SUPPORTING STATEMENT

Removal of Condition No. 8 on Planning Consent
3/2023/0775

Bowland Forest Farm
Settle Road
Bolton-by-Bowland
Lancs
BD23 4SN

May 2024

Title: Bowland Forest Farm
Refuse Layby Detail

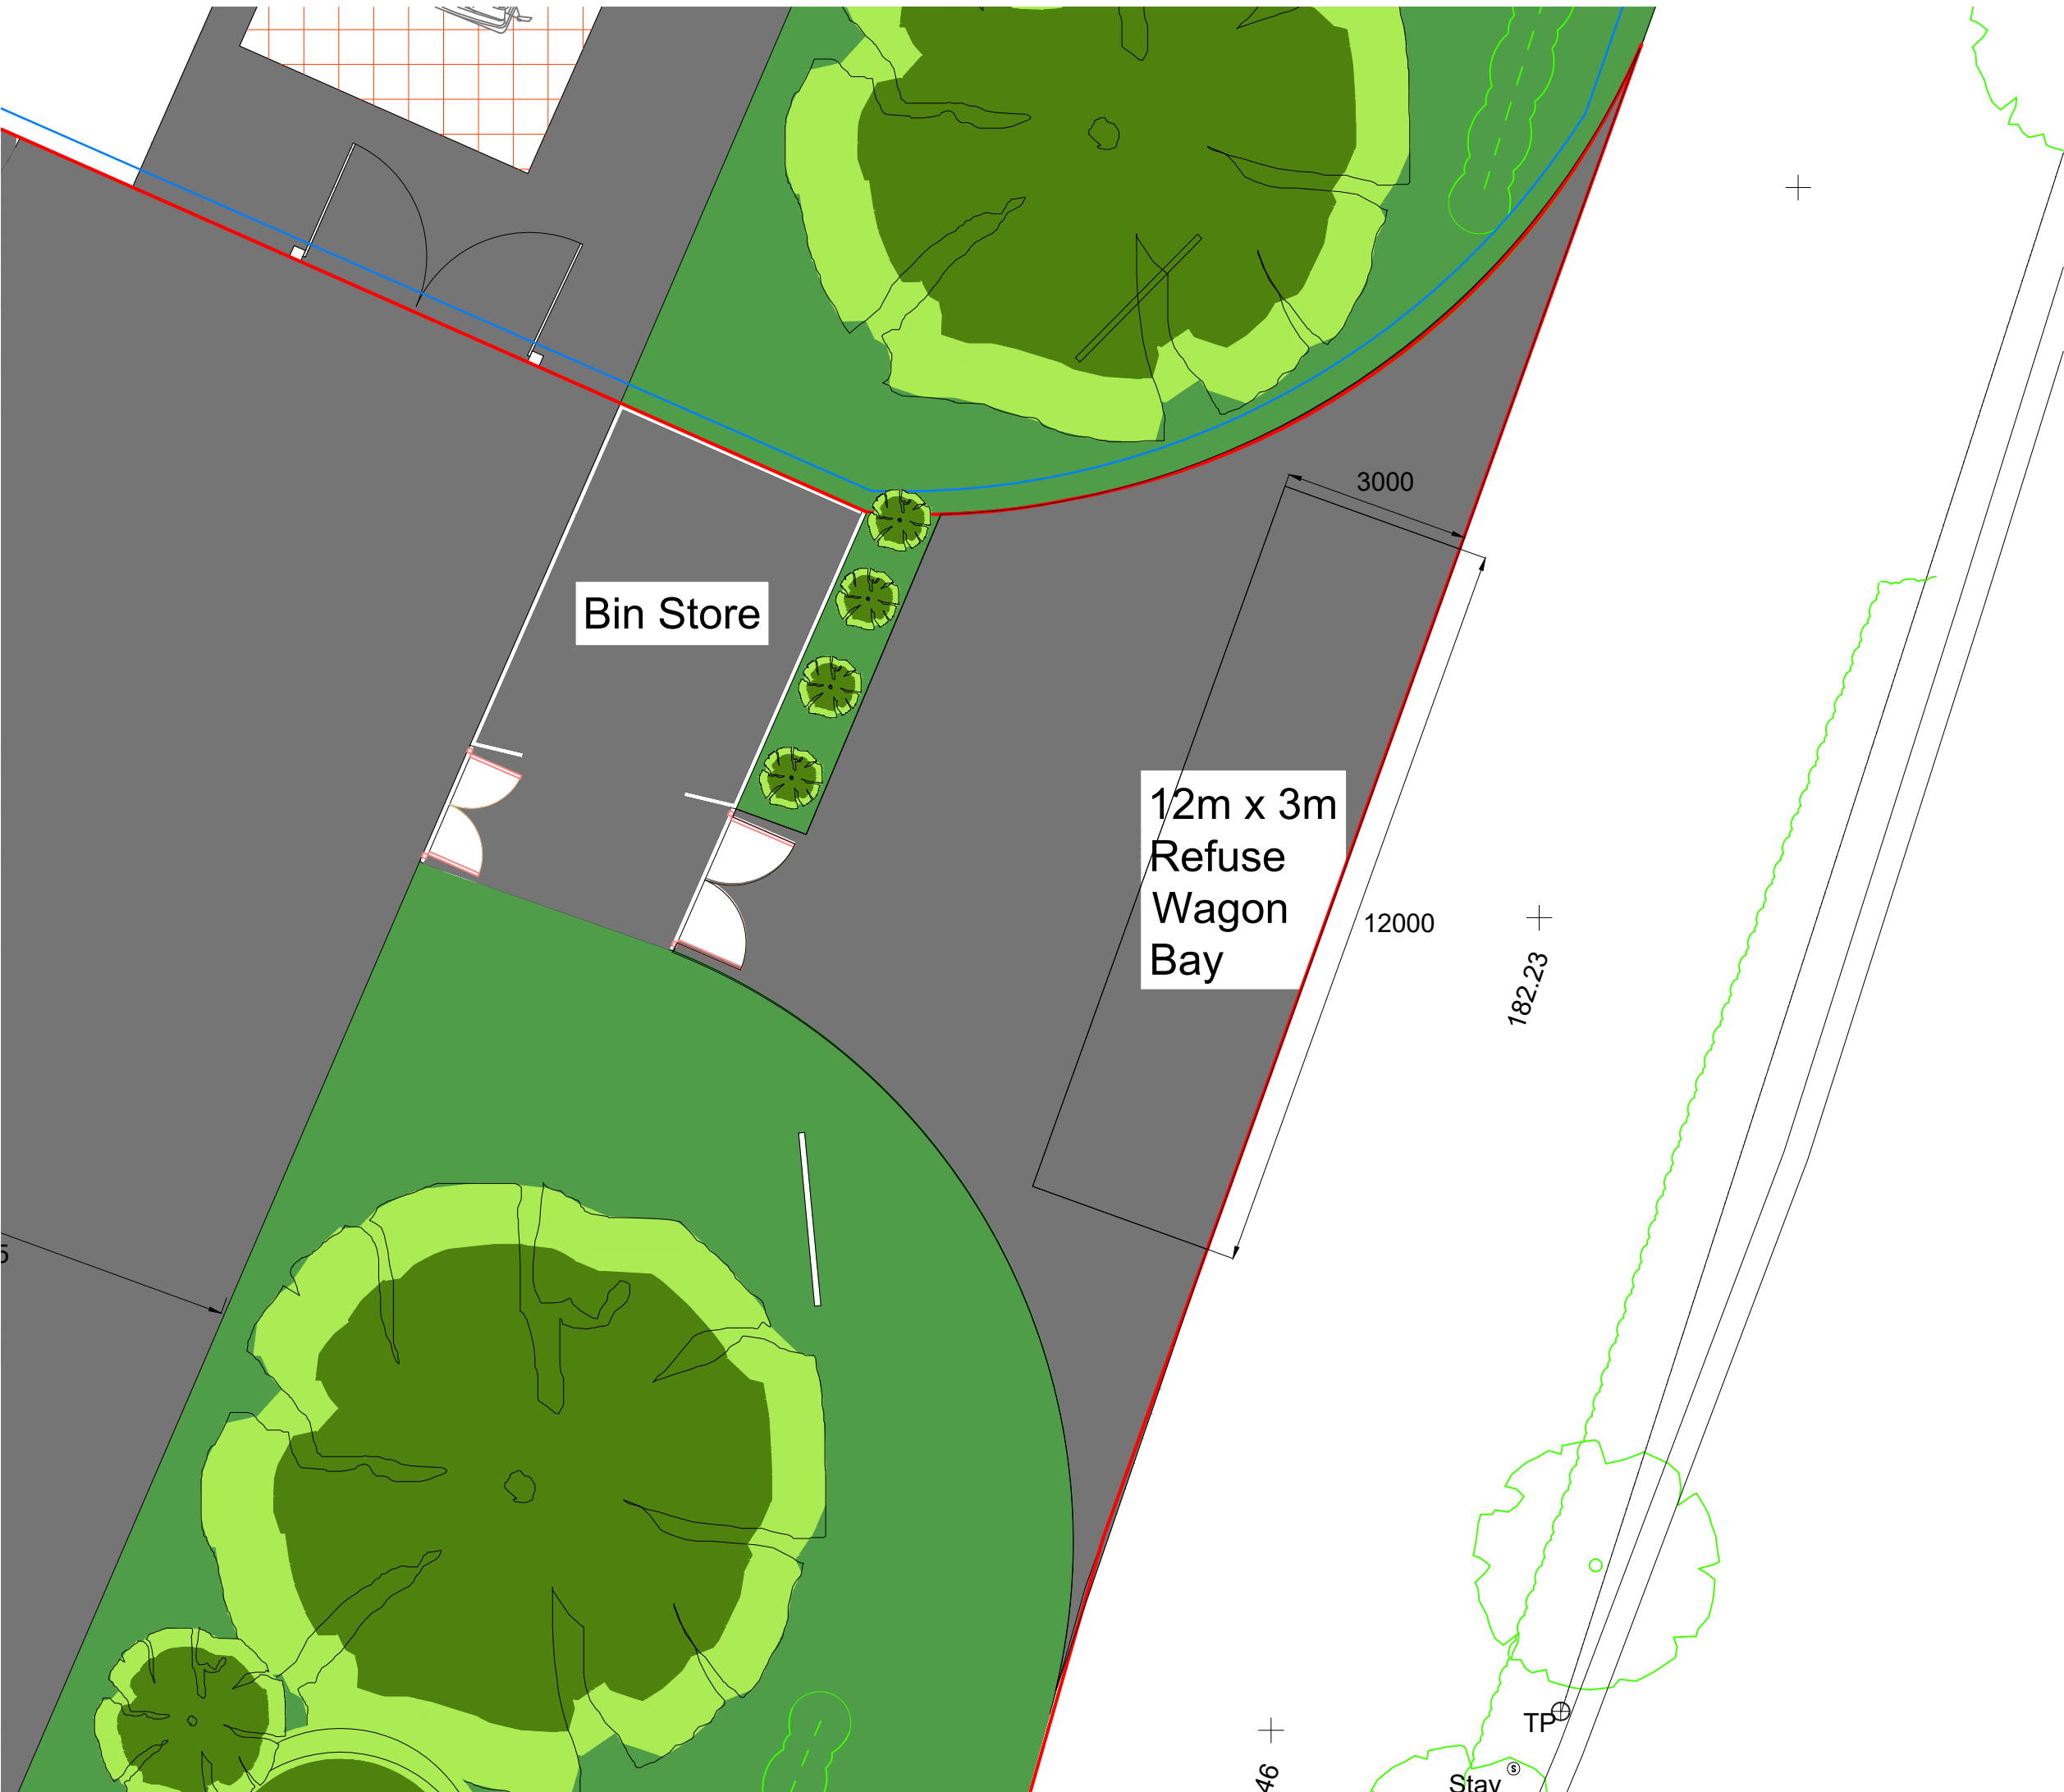
We would seek clarification upon the northern most access which appears to be obstructed by the bin store. This access needs to either be fully closed and reinstated to verge or fully opened. The current proposal is not acceptable.

'This is not supported. As my original comments state, the access needs to be fully closed and reinstated along Settle Road or opened up. The refuse vehicle needs to enter the site, collect, turn and exit onto Settle Road in forward gear so it can access Settle Road in both directions.'

- layby area on Settle Road (on the opposite side of the bin store) infilled / fully closed up
- swept path analysis to show manoeuvrability for refuse wagon within site and to accommodate the refuse wagon leaving the site in a forward gear
